PLANNING AMENDMENT

H13/1216/01.

Description: Erection of a house (amended
siting and boundary, Plot 6)

Location: Off The Sidings (Plot 6)
Moulton

| Job Ref.<br>062-00 | Drawing No.<br>20B |

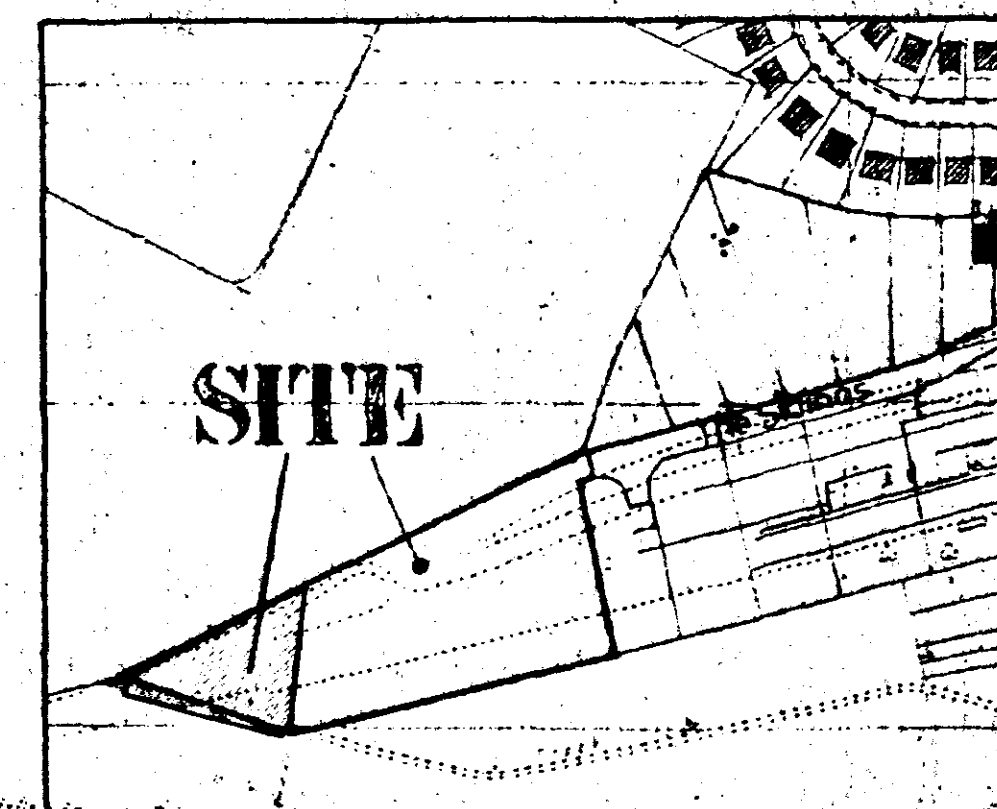
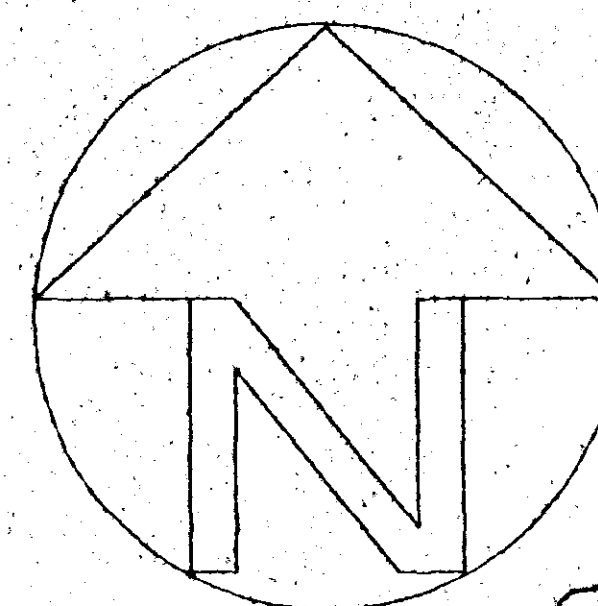
REMOVED GARAGE

CLIENTS AMENDMENTS TO HOUSE.

Amendment: Revised garage and minor amendments to house
Dwg nos. 23A, 22A & 20B

Drawing No.  
 23 D

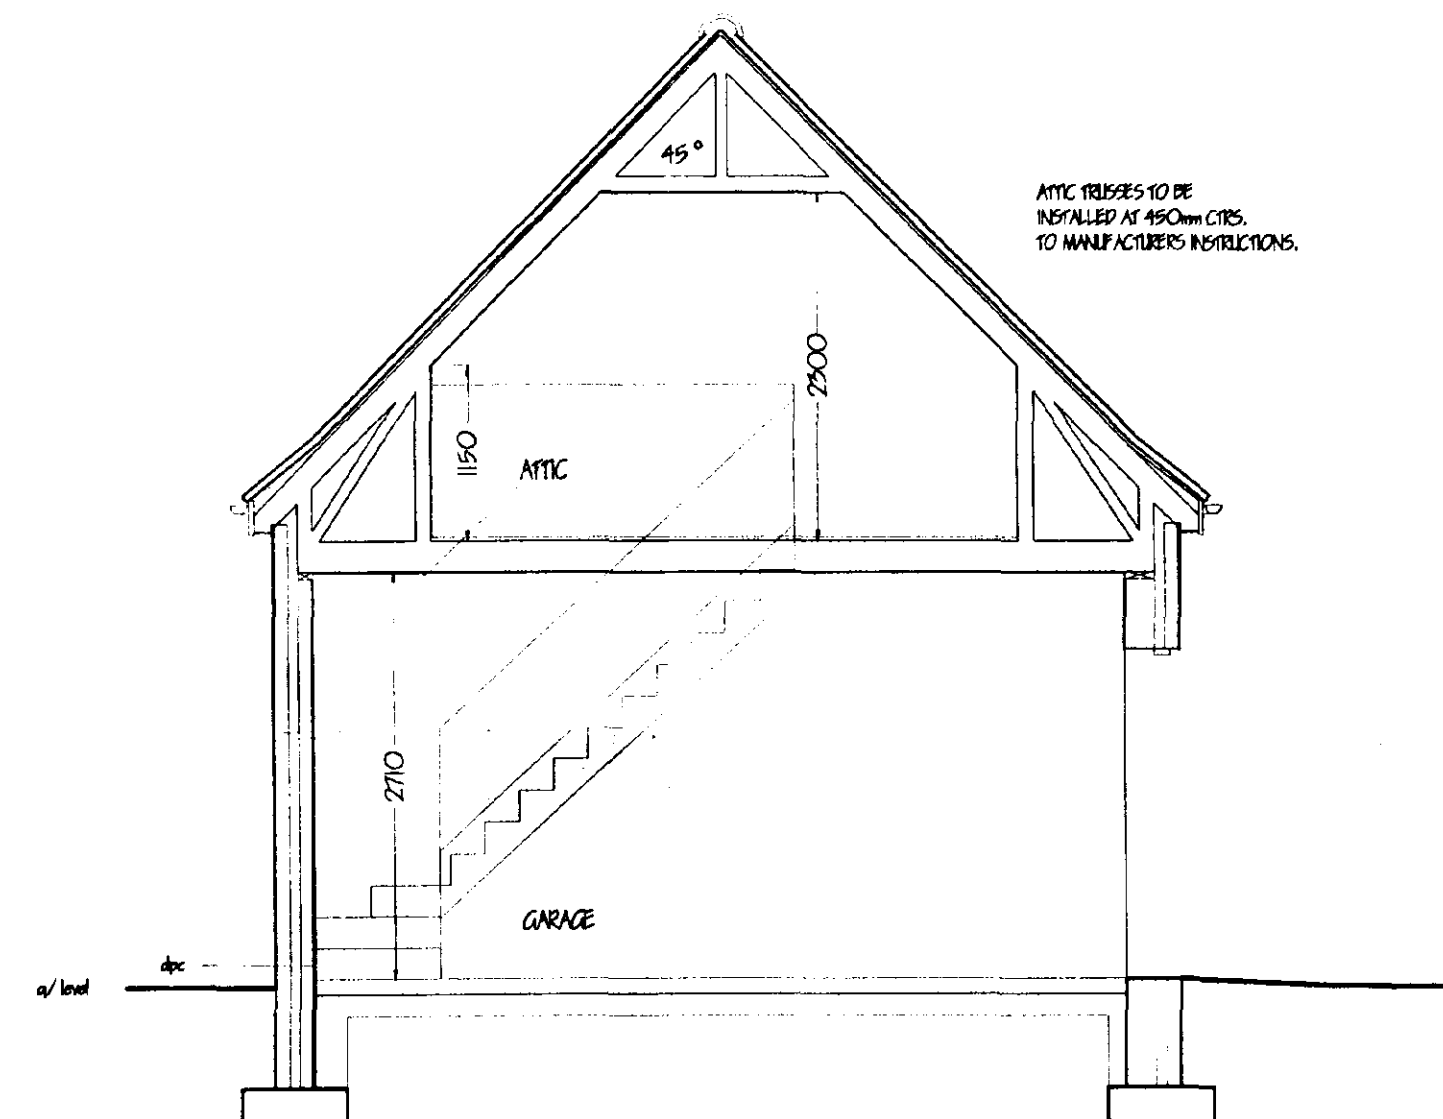
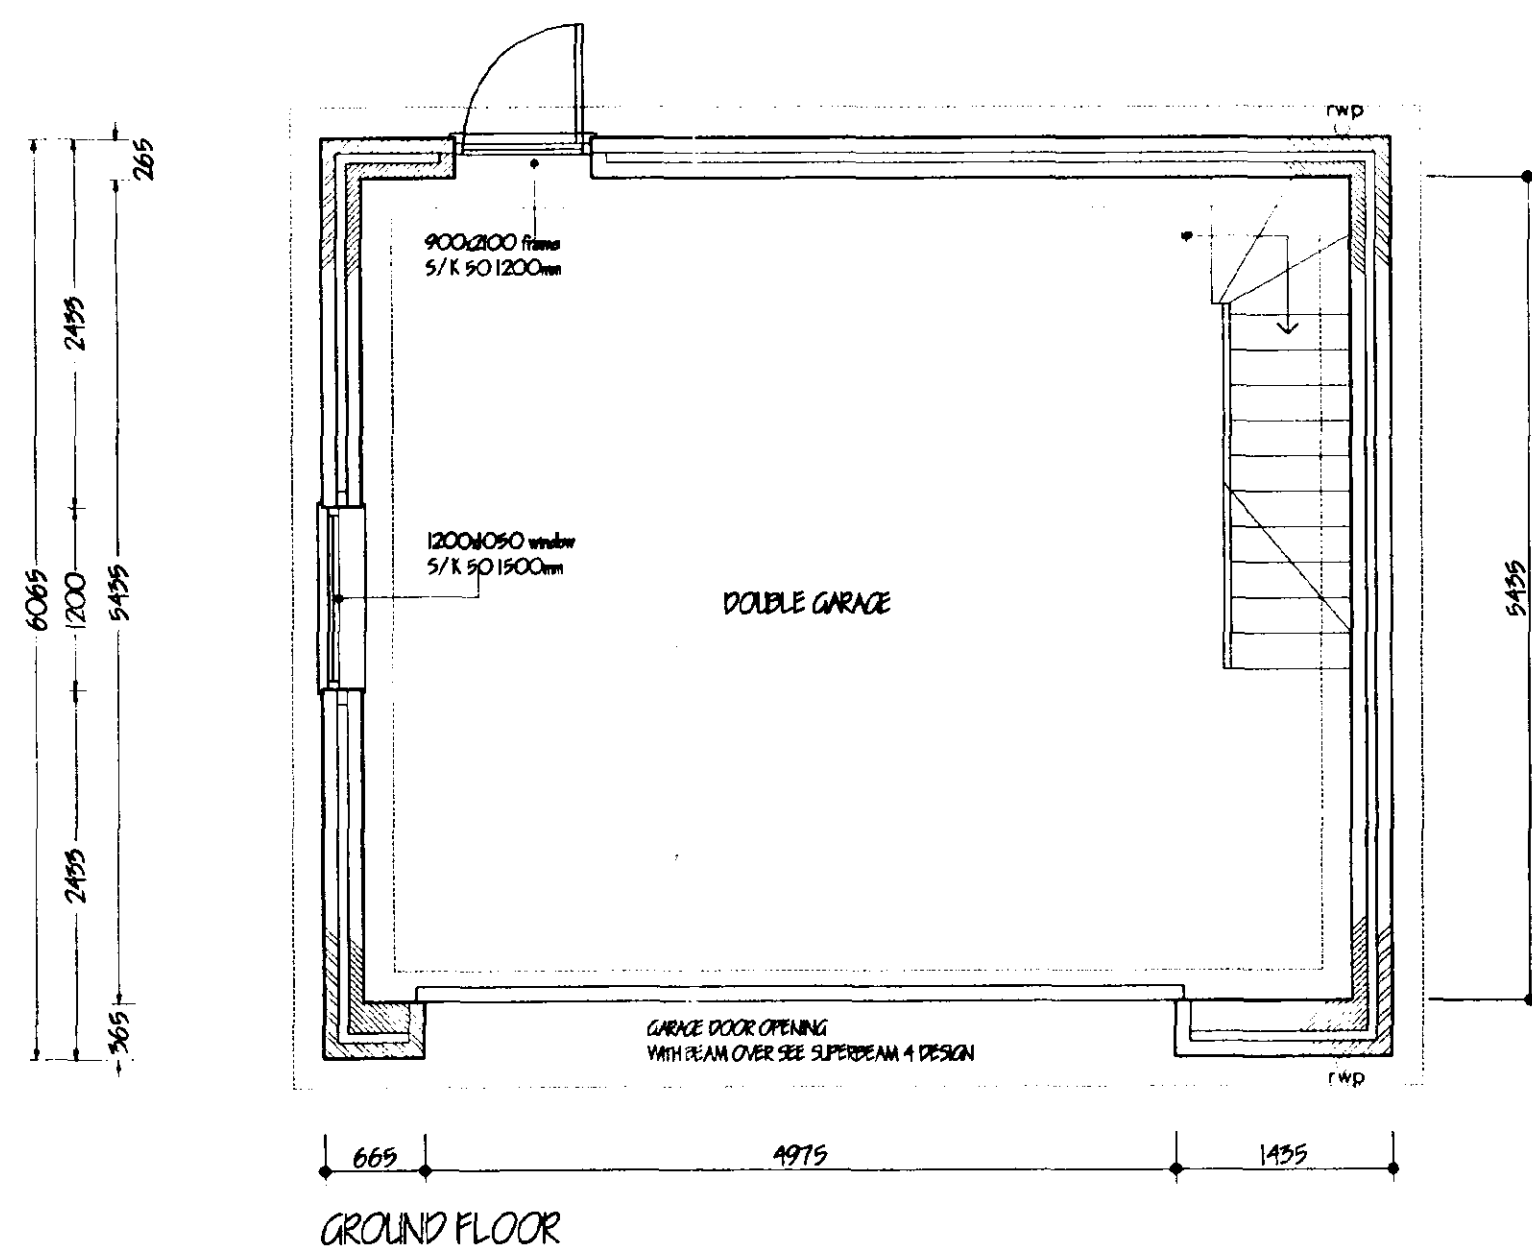
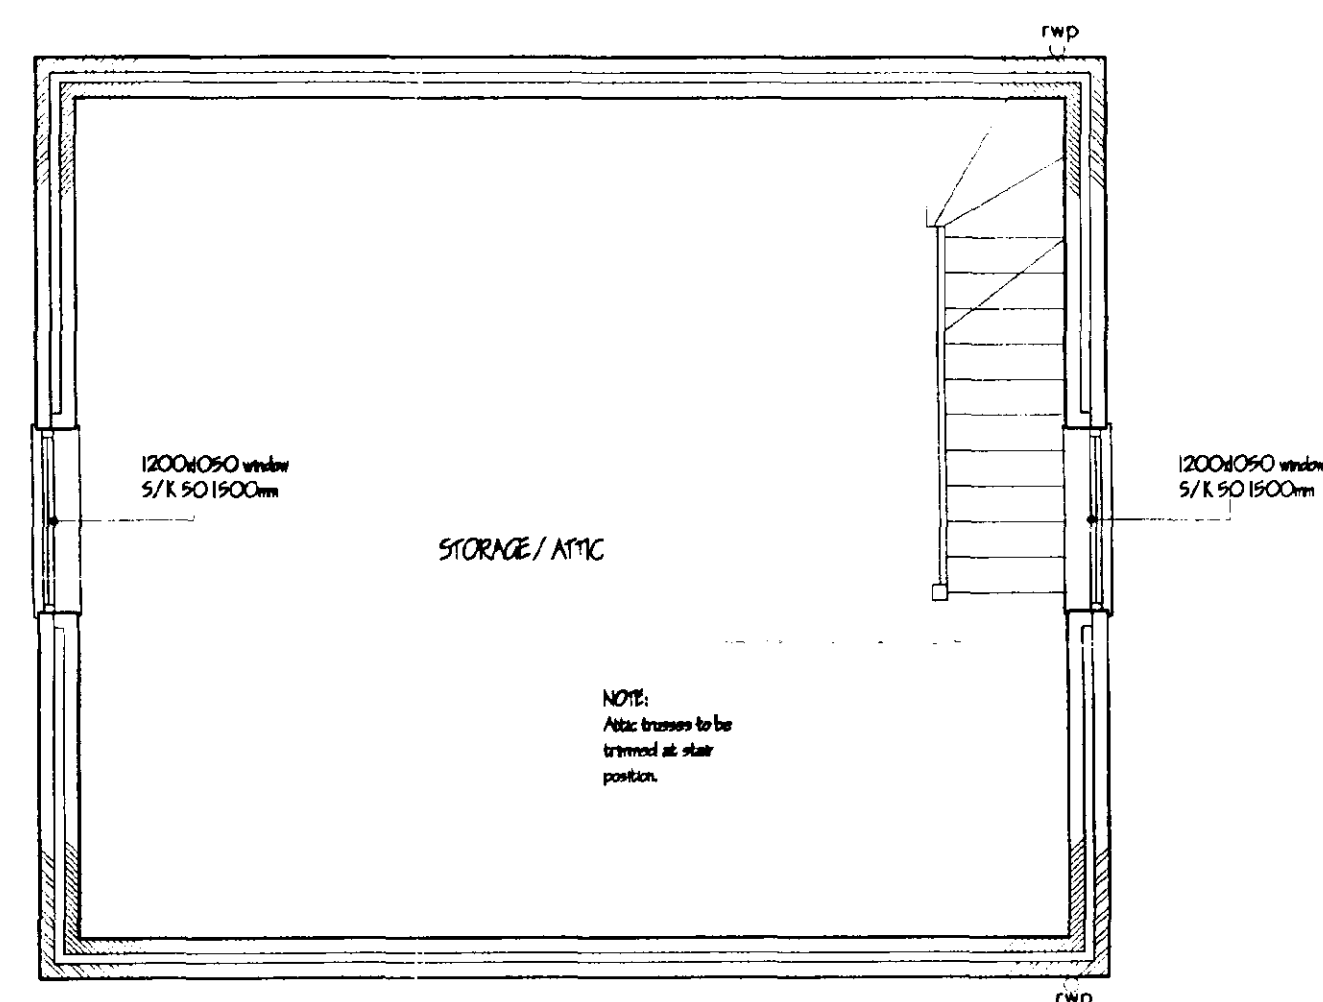
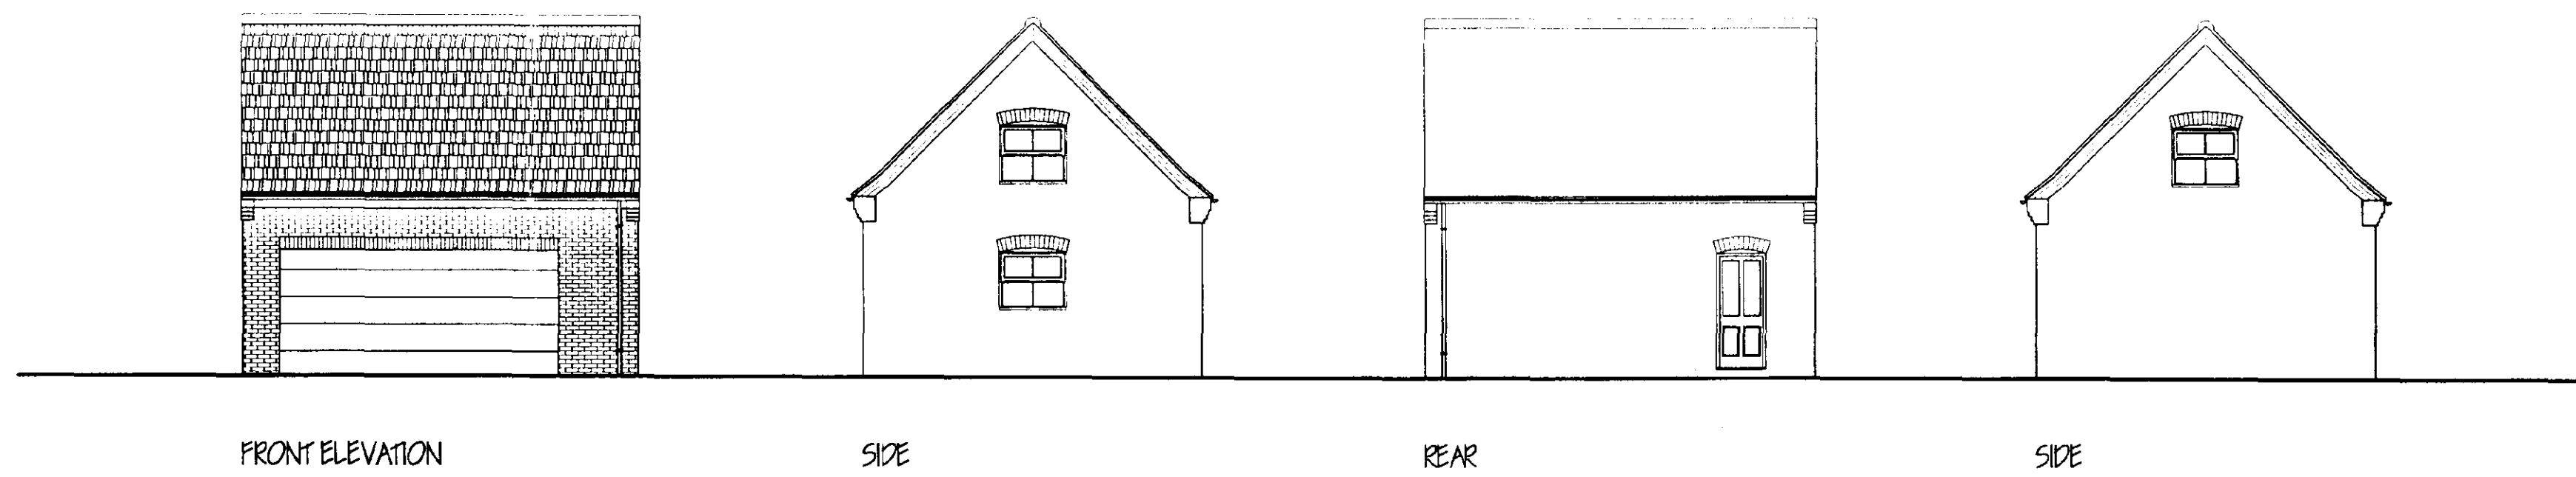
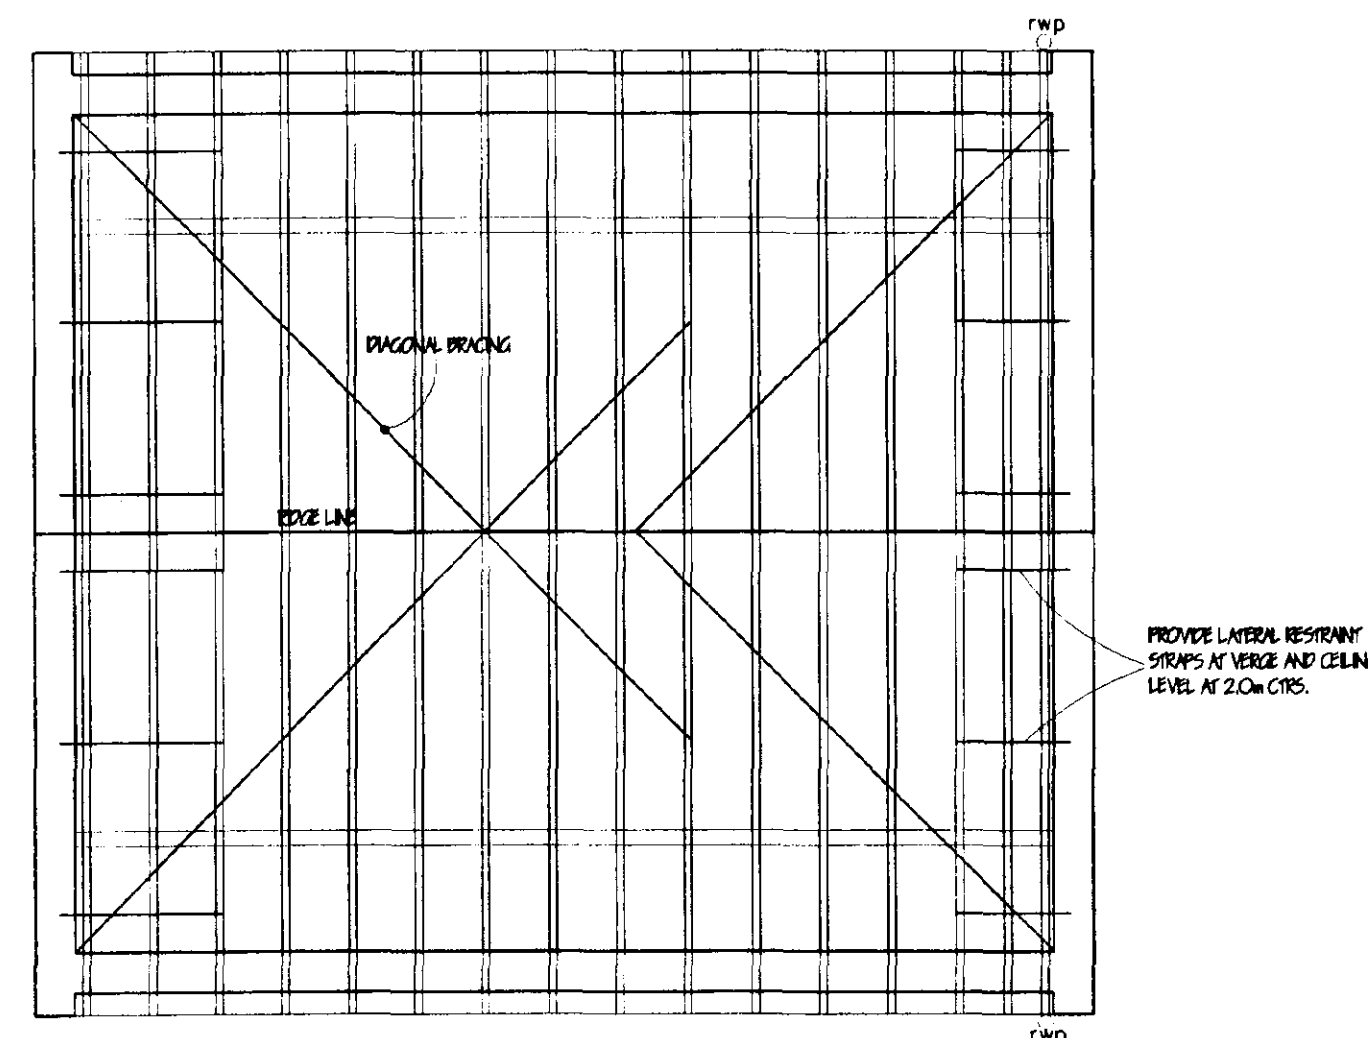
GARAGE DOOR CHANGED FROM DOUBLE TO LARGE SINGLE DOOR.

Amendment: Garage door changed from a double to a large single door
Dwg.No. 062/00/23D
